February 13, 2023

**Re: McMahon Market Place Lots 9B, 9C, & 9D - 5760 McMahon Blvd NW
Erosion and Sediment Control Plan
Engineer's Stamp Date 11/28/2022 (A11E011I)**

James D. Hughes, P.E.
Principal Engineer, Planning Dept.
Development and Review Services

TEMPORARY EROSION AND SEDIMENT CONTROL PLAN

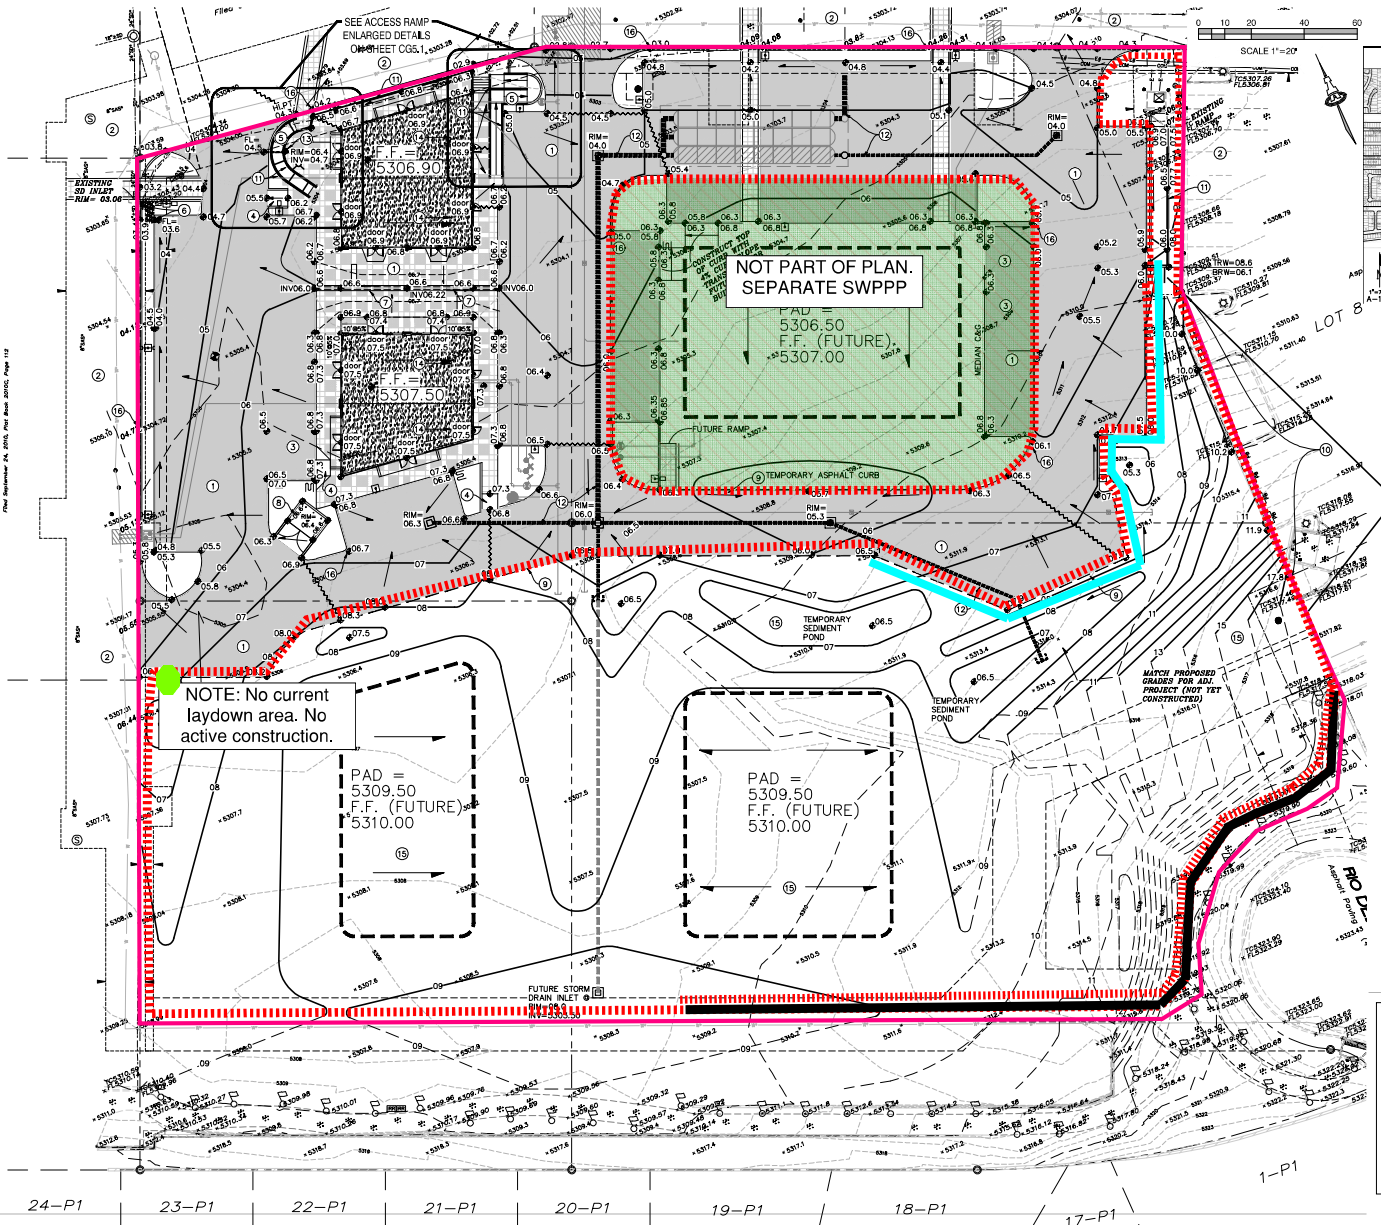
1. You must submit a revised SWPPP, NOI, and ESC Plan for the remainder of the disturbed portion of the McMahon Marketplace "Common Plan of Development or Sale" before the City can approve this new ESC Plan and NOI for Lot 9B. After you split the existing site into two separate areas of control, the City will review the ESC Plans, NOIs, and SWPPPs side by side to ensure no gaps between them.

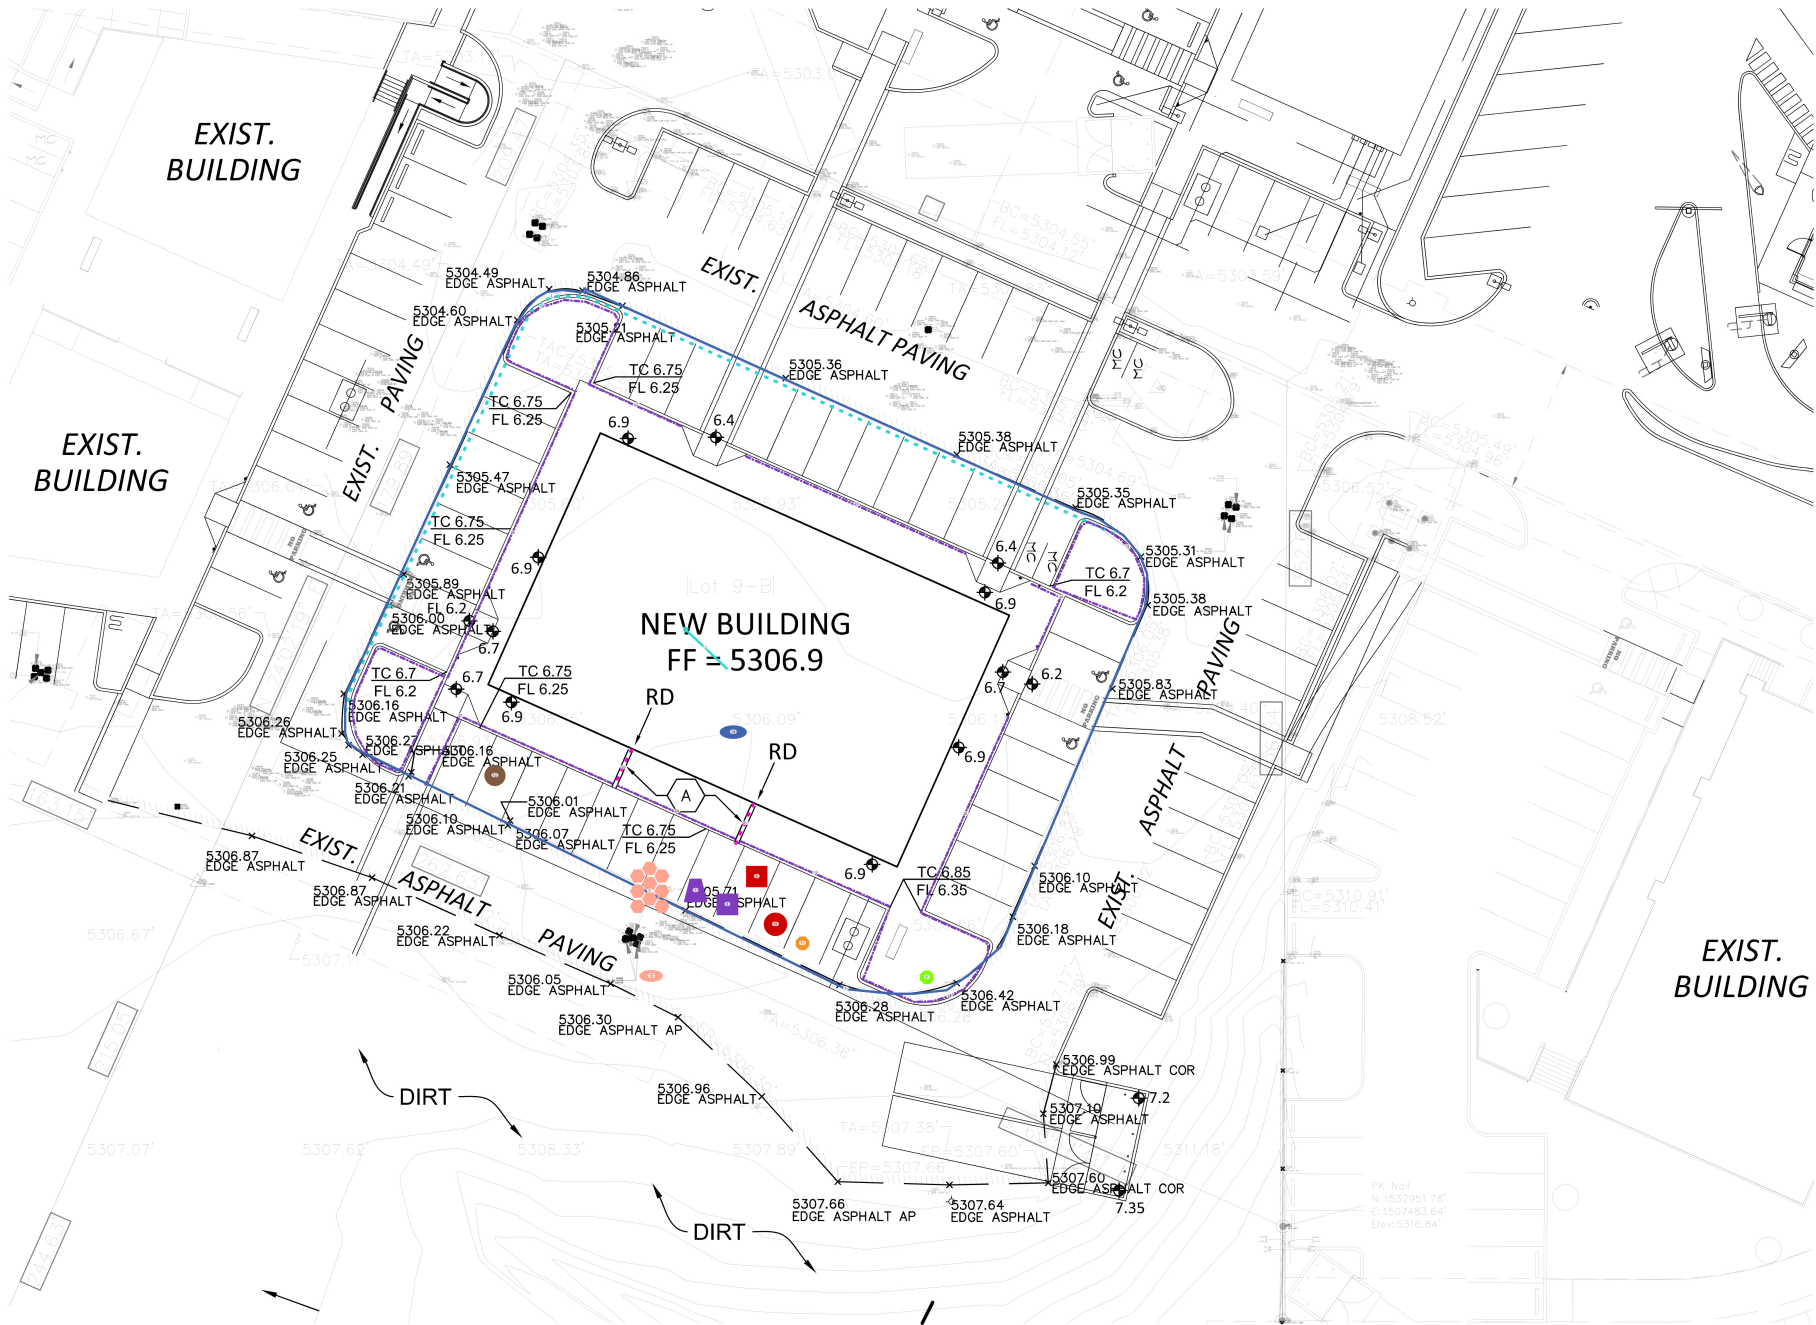
5. The legend includes a line type for the "Property Boundary /Limit of Disturbance" but the property boundary & limit of disturbance are at different locations on the site and the property boundaries are not accurately shown on the ESC Plan. Show the lot lines accurately using a different line type and label the lot numbers on the ESC Plan.

6. Add inlet protection at all of the inlets that this site drains to. Show storm drains and direction of surface flow.
7. The SWPPP must include site-specific interim and permanent stabilization per CGP 9.4.1.c.i. The Landscape Plan can be used to satisfy this requirement and should be submitted separate from the ESC Plan with the application to the Stormwater Quality Section of the Planning Department and they should be included in the SWPPP. Provide a specification on the ESC Plan for any disturbed areas not covered by the Landscape Plan.

8. Describe the nature and extent of construction activities (CGP 7.2.2.). Include the size of the property, and the size of the area of land disturbing activities. The estimated area to be disturbed, 8.39 acres, on sheet 2 seems excessive. It should be noted that the lot area, 0.92 acres, shown on sheet 4 is part of a 10 acre Common Plan of Development or Sale.
